**Our ref:** NO/2014/106998/01-L01

**Date:** 17 September 2014

**DEVELOPMENT OF UP TO 520 HOMES INCLUDING AFFORDABLE HOUSING AND HOUSING FOR THE ELDERLY, RELOCATION OF LONGRIDGE CRICKET CLUB TO PROVIDE A NEW CRICKET GROUND, PAVILLION, CAR PARK AND ASSOCIATED FACILITIES, NEW PRIMARY SCHOOL, VEHICULAR AND PEDESTRIAN ACCESS LANDSCAPING AND PUBLIC OPEN SPACE, WITH ALL MATTERS RESERVED EXCEPT FOR ACCESS.**

**LAND EAST OF CHIPPING LANE, LONGRIDGE**

e*SCAPE
 urbanists
 Project Title
 Higgins Brook, Longridge
 e*SCAPE Job No.
 013-008
 Client
 Barratt Homes
 Drawing Number
 013-008-P008
 Revision
 REV D
 Drawing Title
 Illustrative Masterplan/
 Indicative Layout
 Scale
 1:1250 @ A1
 Date
 Dec'13

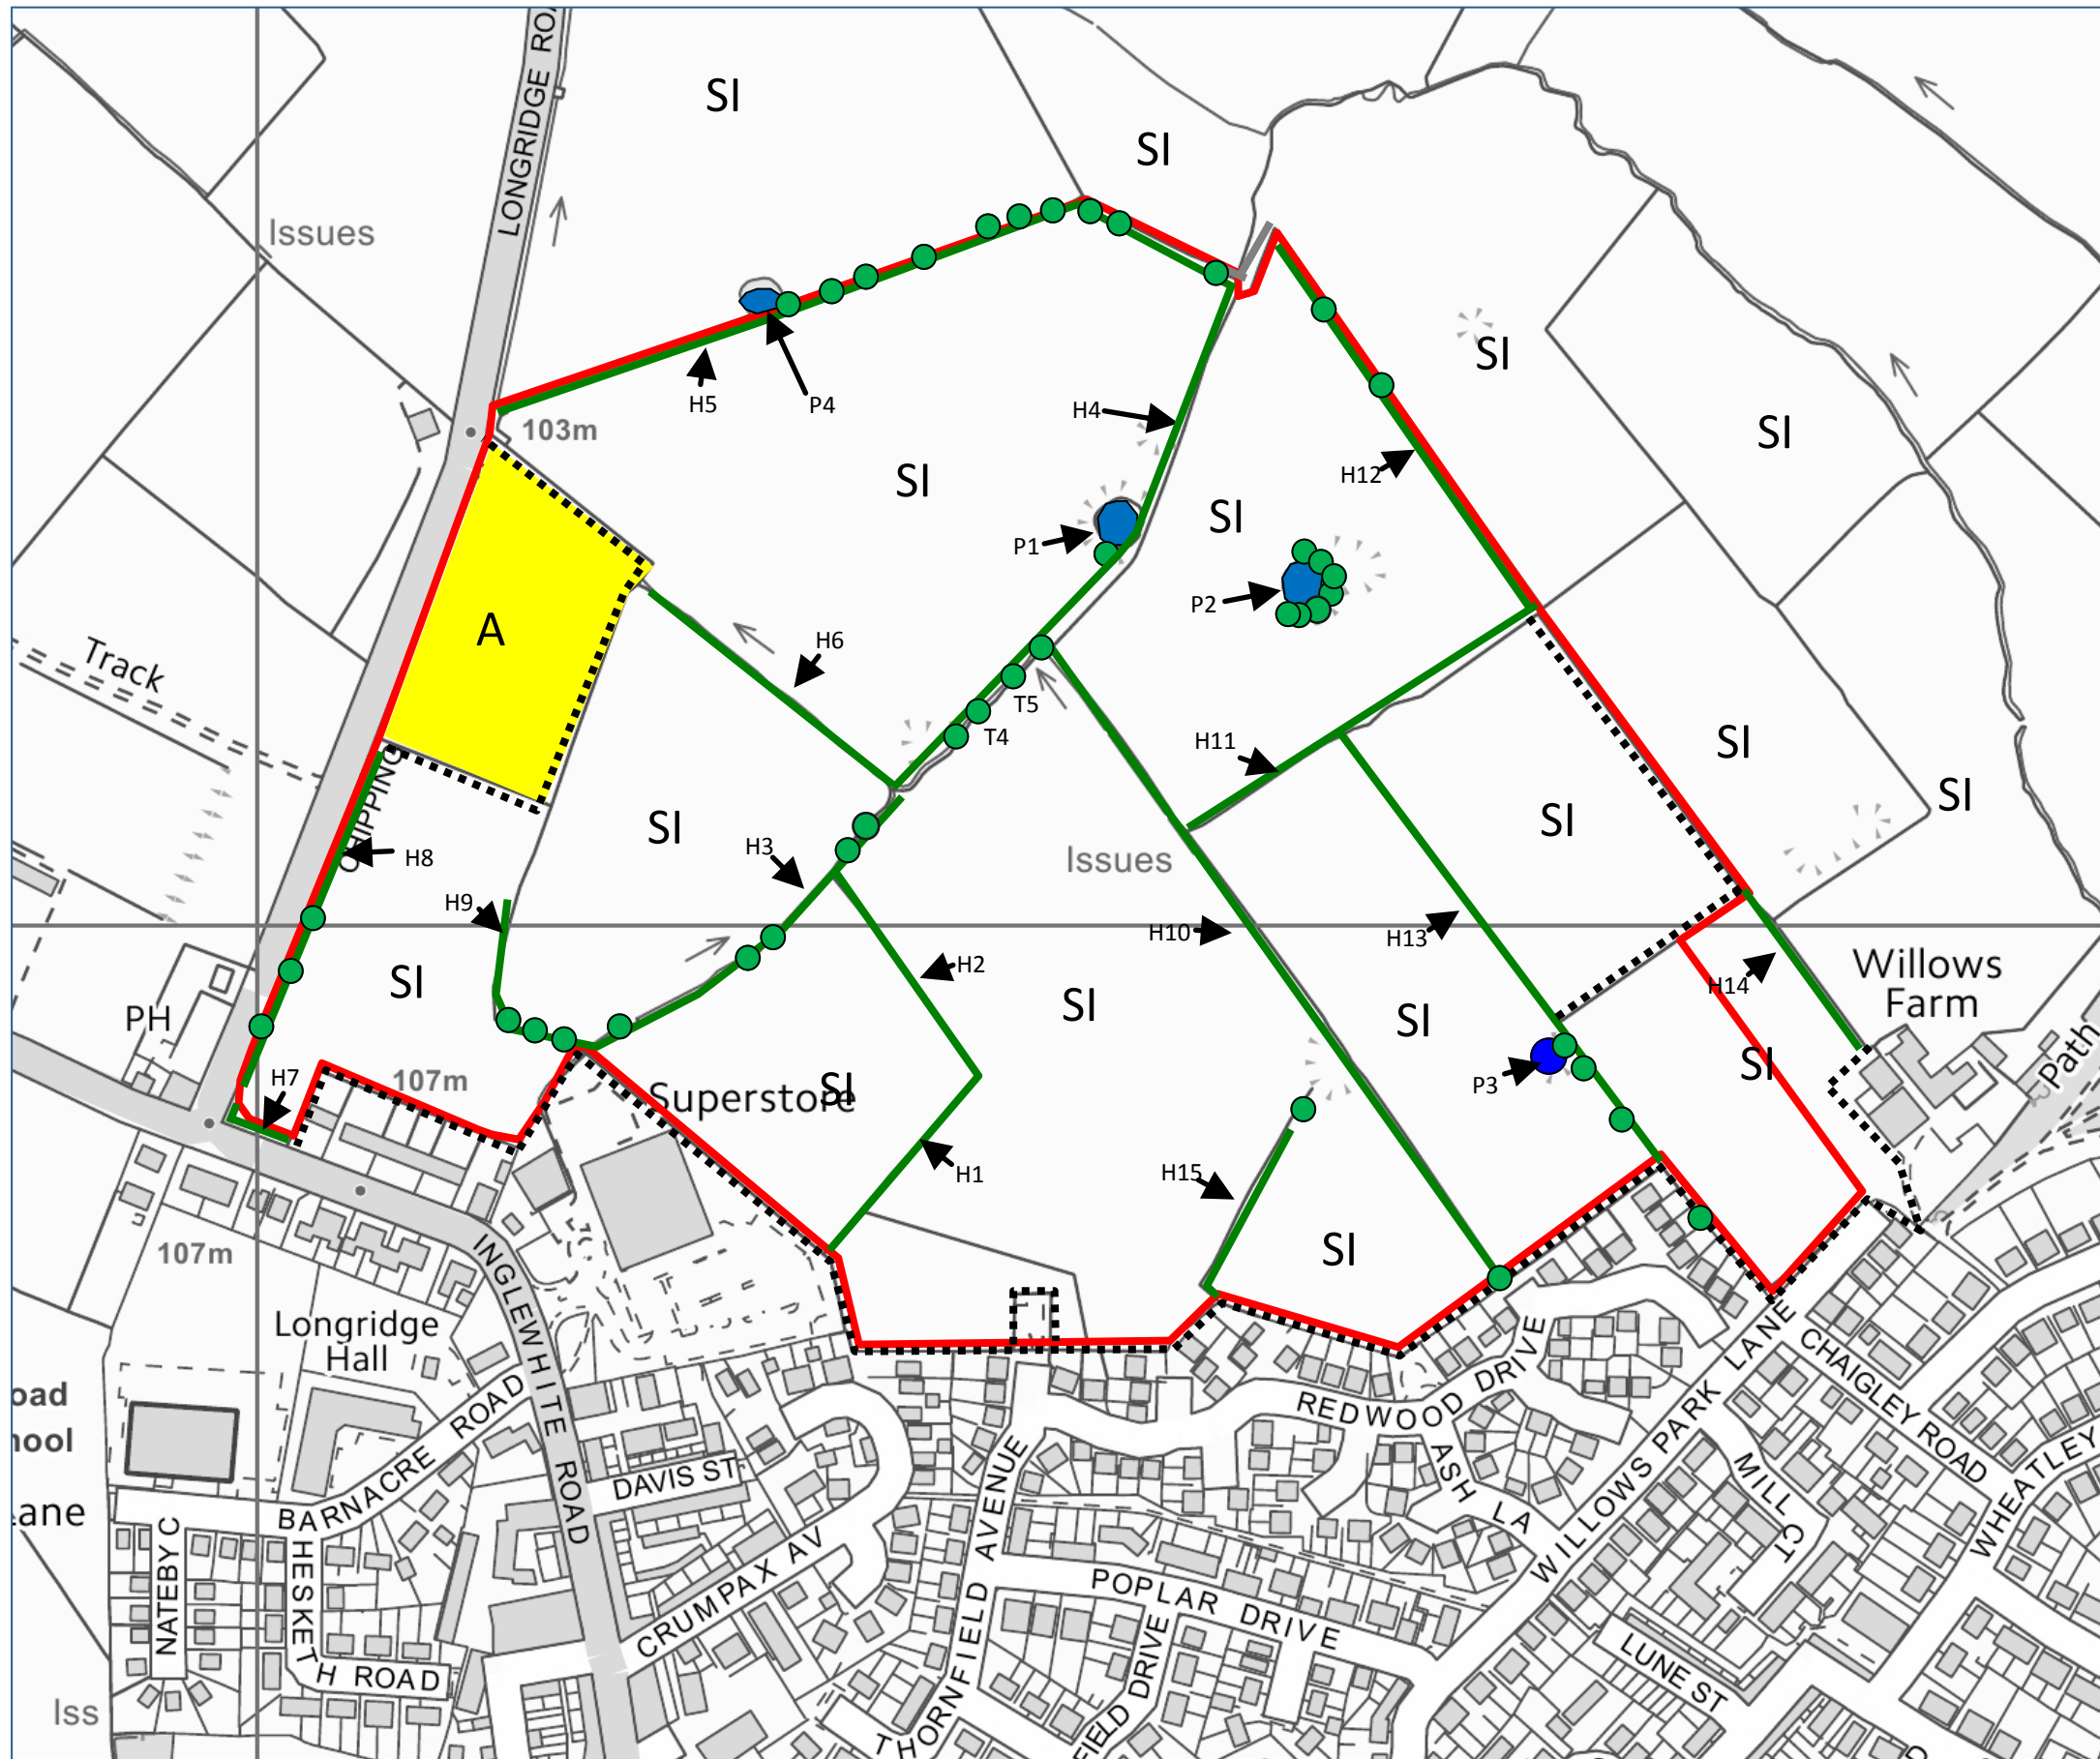
The submitted illustrative layout (Ref: 013-009-P008 Rev D, dated December 2013) could have a detrimental impact on the aquatic environment.

There are several watercourses, including a culverted section, and ponds existing on the site. The illustrative masterplan indicates that new ponds are proposed on the line of the existing watercourses, and that it is proposed to create new watercourses with online ponds that are directly connected to the existing watercourses.

We advise against the creation of online water features, such as lakes and ponds, created on the line of a watercourse interrupt the continuity of the river environment and restrict colonisation and drift by the aquatic fauna. The ecology becomes more lake-like and there is increased siltation. We also have experience of online ponds being stocked with non-native fish species which can have a detrimental effect by migrating into the wider aquatic environment. Ponds with ditch or stream inflows have higher pollutant levels, significantly fewer plant and animal species, and many more management problems than other pond types. Stream-fed ponds also fill up much more quickly and often they fill completely within a decade or two.

The application presents an opportunity to remove the culvert on site and restore this section of watercourse to open channel, free from development and incorporating an appropriate buffer zone.

We recommend that a clear, unobstructed buffer between the edge of the watercourse and the proposed development is incorporated in to the layout of the proposed development. The buffer zone should be free from built development, including lighting, domestic gardens and formal landscaping.

Instead, we advise that water features should be created off-line. If pollution incidents or problematic algal blooms occur in off-line features there is little danger that they will affect local watercourses. Excessive weed growth in an off-line feature can be treated with herbicides or by physical means without affecting local watercourses.
